**Consultation Response from KC,
Highways Development Management**
2026/91763 Land off Barnsley Road, Denby Dale, Huddersfield,
Erection of 40 residential dwellings and associated works
Date Responded: 24/08/2026
Responding Officer: CNB
Responding Ref: k17-20/3

The internal layout is shown on Site Layout Plan No 2530-SI-02 rev J.

SITE LAYOUT PLAN - 2530-SI-02H
BARNESLEY ROAD, DENBY DALE
NEWETT HOMES
SCALE:1:500@A1 - AUGUST 2025

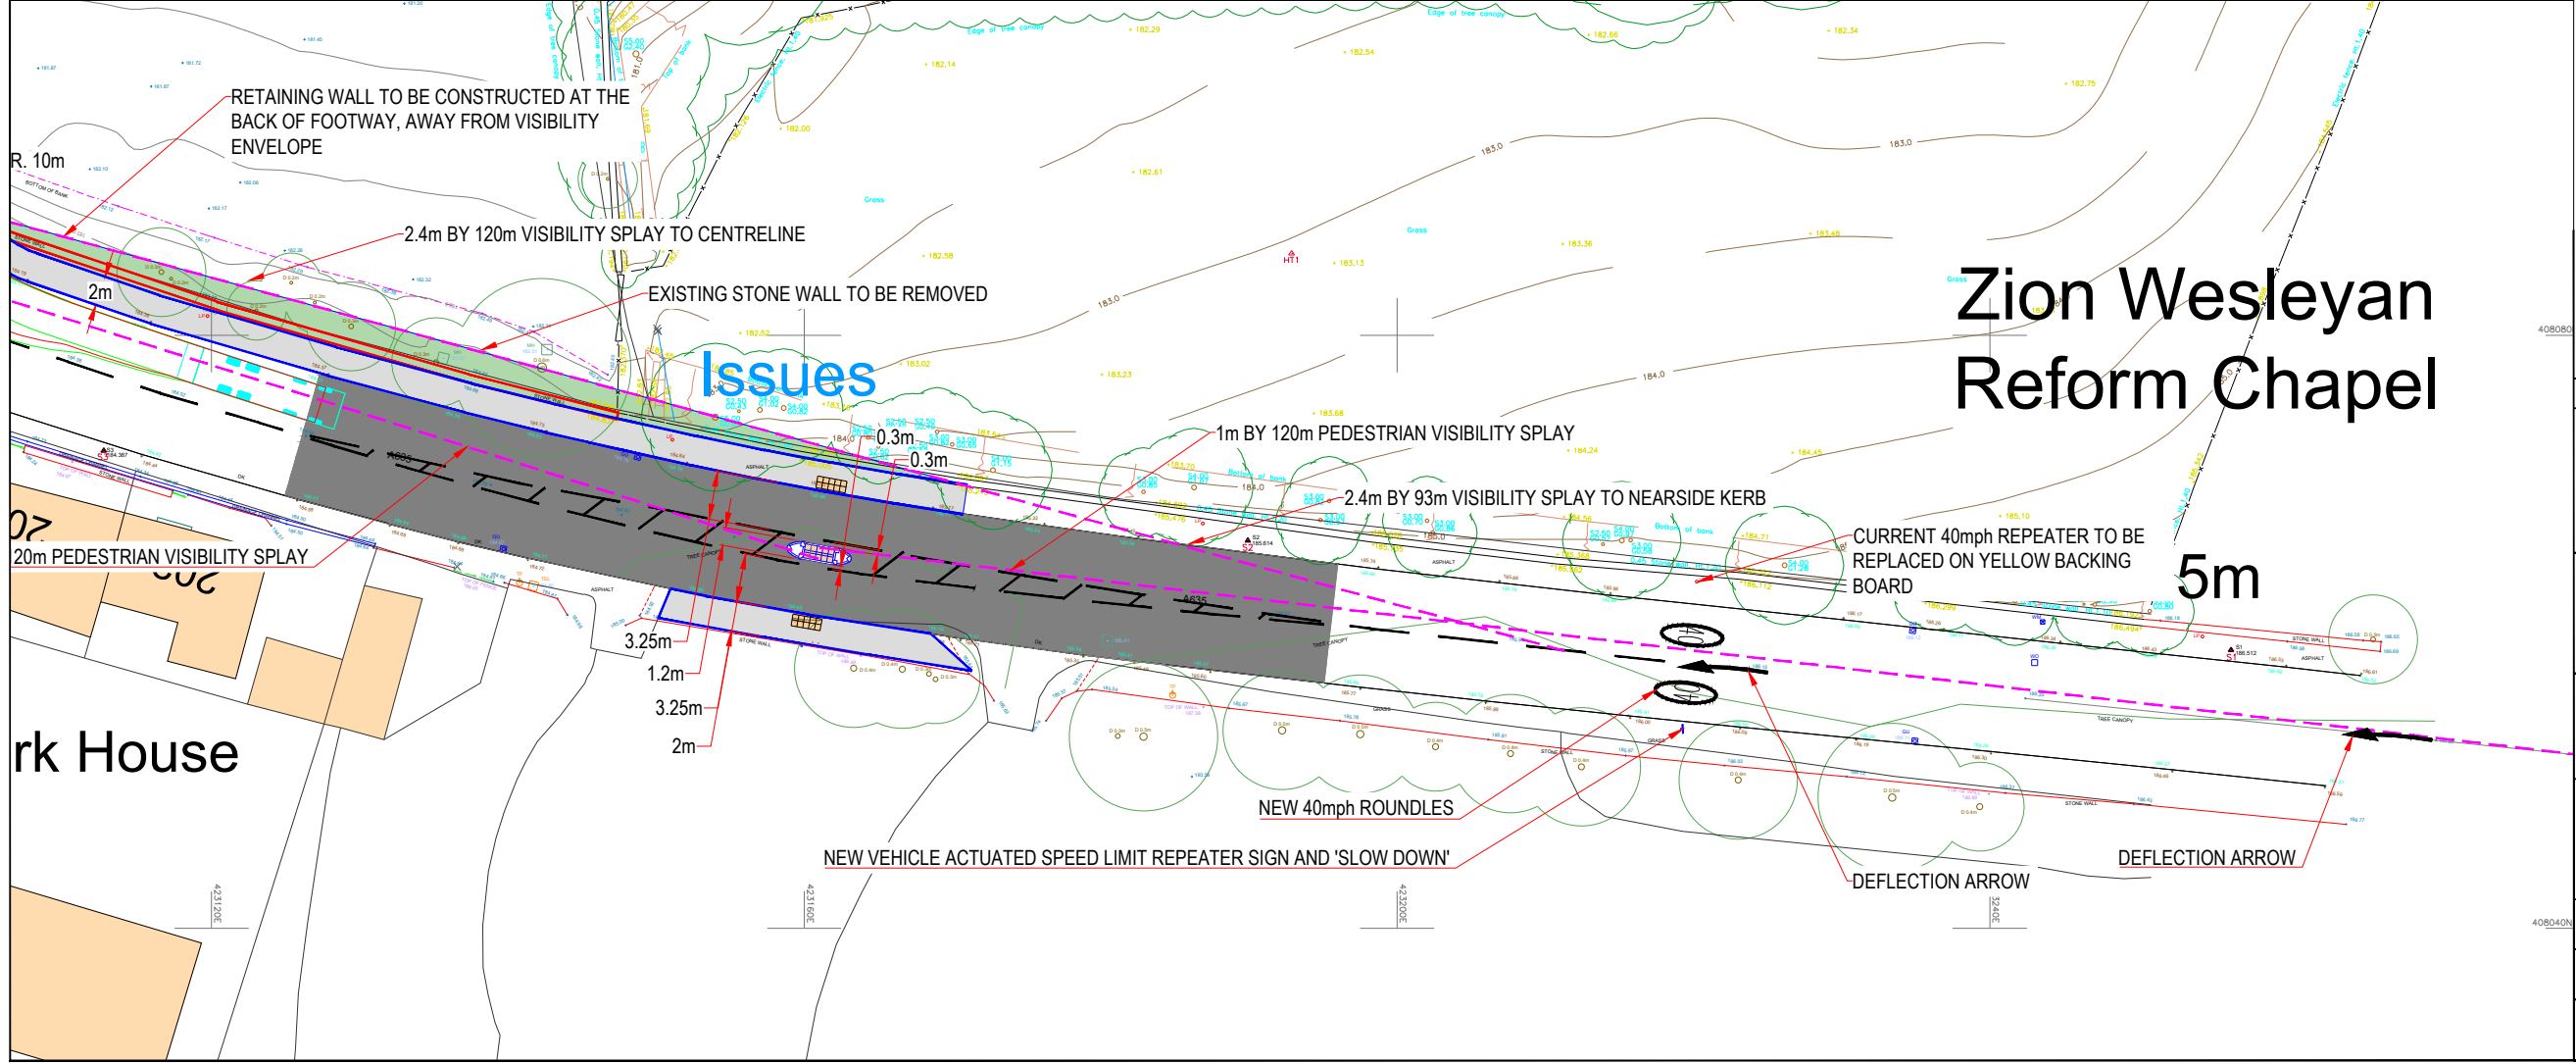
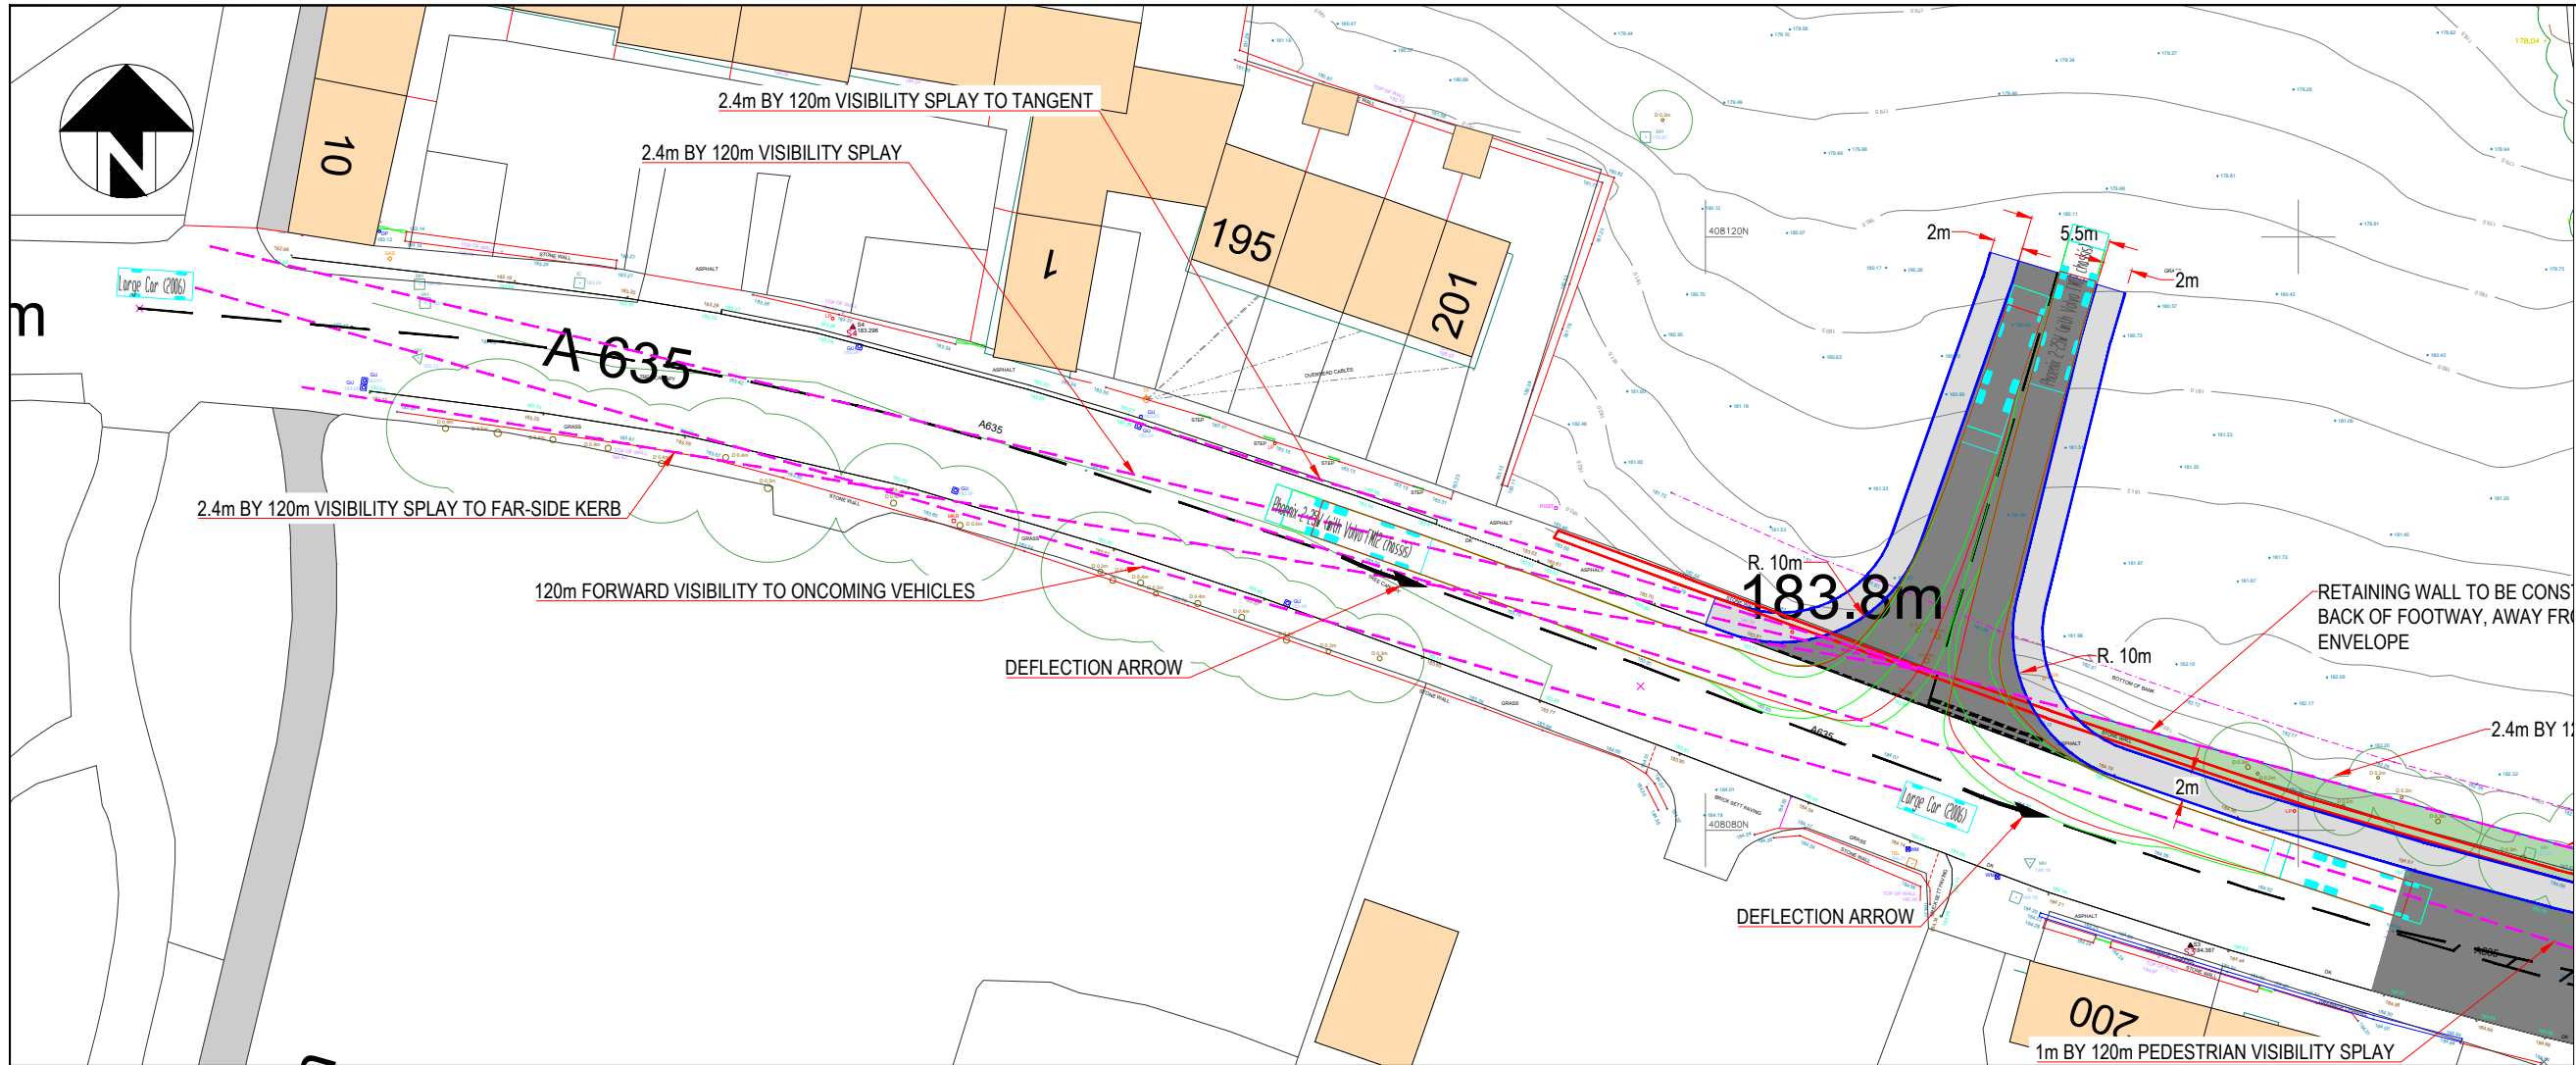
All internal highway widths are a minimum of 5.5m with footways of 2m width, however it is noted that there is no footway to the front of plots number 2 to 6 and without a footway to the frontage of these dwellings the layout would not be acceptable for adoption by the Kirklees s38 team and would not conform to Kirklees policy on sustainable and active travel.

The access road is located on a sloping site heading downwards from Barnsley Road. Long sections were provided with the previous approval but are missing from the current application, these should be provided to show that any amendments to the layout have not affected the gradients and transitional curves and that they are still within local standards. Shared surfaces should have gradients of less than 1:20 to comply with the Equalities Act 2010 and any with gradients steeper than 1:20 should be constructed as type B residential streets with 2m footways.

A drawing should be submitted showing that 25m forward visibility is achievable on the speed-bend adjacent to plot 28 and that 2.4m x 25m visibility splays are achievable at the junctions near plot 10, the access to plots 12 - 15 and the turning head adjacent to the pumping station. Any obstructions to visibility i.e. street furniture, parking bays or landscaping etc should be removed or be no more than 0.9m in height. This can be added as a condition.

Tracking details for an 11.85m refuse vehicle entering/exiting the site and turning within the turning heads will need to be provided with the current application and this can be conditioned.

The access to the private drives should be over a dropped kerb crossing and ramps of a maximum gradient of 1:12 should be included as the transition from footway to shared surface. These should be clearly indicated on a drawing.

Plots 1, 20, 21, 27 28 and 31 are 5-bed properties and require a minimum of 3 off-street parking spaces. For all these plots suitable parking is provided in a mixture of integral garages and driveway parking and this is acceptable.

Plots 2, 3, 7, 8, 9, 10, 17, 18, 19, 22, 23, 26, 30, 33, 34, 35 and 40 are 4-bed properties and require a minimum of 3 off-street parking spaces. Plots 7 and 35 provide 3 off-street parking spaces in a detached single garage and double tandem driveway parking and these are acceptable. Plots 2, 8, 9, 19, 22, 26 and 40 have an acceptable integral garage but the driveway parking may be too narrow to allow pedestrian access to the dwellings when 2 cars are parked, and this would need to be addressed. Plots 3, 7, 10, 17, 18, 23, 30, 33, 34 and 35 have integral garages that are below standards and also don't have sufficiently wide enough driveways to allow pedestrian access to the dwelling when 2 cars are parked, and this would need to be addressed. It should also be noted that the requirement for a 2m footway

along the frontage of plots 2 to 6 will also reduce the space available for off-street parking unless the plots are set back to allow for the footway.

Plots 4, 5, 6, 11, 16, 24, 25, 29, 32, 36, 37, 38 and 39 are 3-bed properties and require a minimum of 2 off-street parking spaces. Plots 4, 5, and 6 have acceptable sized driveways for 2 cars to park off-street, however it must be noted that a 2m footway would be required along the frontage of these dwellings and this would remove driveway parking unless the dwelling plots were set back to allow the 2m footway. Plots 11, 16 have suitable driveway parking for two tandem spaces and are acceptable. Plots 24 and 25 have suitable off-street parking for 2 cars and are acceptable, although parking at plot 24 might be a bit tight. Plot 29 has suitable driveway parking for 1 car, but the integral garage is below standards for a parking space, and this would need to be addressed. Plot 32 has suitable driveway tandem parking for two cars and is acceptable. Plot 36 has suitable driveway parking for 1 car, but the integral garage is below standards for a parking space, and this would need to be addressed. Plots 37 and 38 have suitable driveway parking for 2 cars but parking may be a bit tight. Plot 39 has suitable driveway parking for 1 car, but the integral garage is below standards for a parking space, and this would need to be addressed.

Plots 12 to 15 are quarter houses with 1-bedroom and would only require 1 parking space and these are shown on drawing No 2530-SI-02 Rev J, however there may be issues manoeuvring in and out of all the spaces and we wouldn't like to see parking with a requirement to reverse out on to the main spine road for highway safety reasons. We request that a swept path analysis is submitted to show that cars can access the spaces and turn within the parking area so they can enter and exit the parking area in forward gear.

The visitor parking spaces to the rear of the turning head adjacent to plots 25 and 26 and the one on the private driveway opposite plot 40 should have a minimum of 1m hard standing running behind them to allow vehicle occupants to exit their vehicle on a hard standing rather than on to a grass verge. This should be conditioned and amended during the detailed design phase. The visitor parking space adjacent to plot 23 is acceptable. Other visitor parking spaces are shown as being "on street" and this design is not acceptable to the Kirklees s38 team and so these cannot be used to fulfil the site's allocation of visitor parking spaces, meaning that there is a shortfall of 6 visitor parking spaces. S38 will only adopt parking spaces that are in bays and must be a minimum of 2.5m x 6m. Any other bays (echelon or perpendicular) or private bays will not be considered for adoption. Where parallel parking bays are adjacent Public Open Space or walls, please ensure that, if there is no footway i.e. shared surface carriageway, then there is a minimum 1-metre-wide hardstanding to enable safe entry and exit of the occupants.

Plots 12 to 15 are accessed by a private driveway that would not be accessed by a Kirklees refuse collection vehicle and so a bin collection presentation point has been shown on drawing No 2530-SI-02 Rev J approximately 14.5m from the adoptable highway and as such are above carry distances as given in local guidance and building regulations. We would like to see the collection presentation point relocated closer to the rear of the adoptable highway.

Due to changes in the site housing layout the bin collection presentation point for plots 23 and 24 have been moved from the start of the private driveway that serves these two dwellings to a point approximately 17.5m from the rear of the adoptable highway, and this is above the 8m carry distance between the presentation point and rear of a waste collection vehicle as provided in local waste storage

and collection guidance. The original location of the presentation point in the last approval was at the rear of the footway and was an acceptable distance from the rear of the collection vehicle.
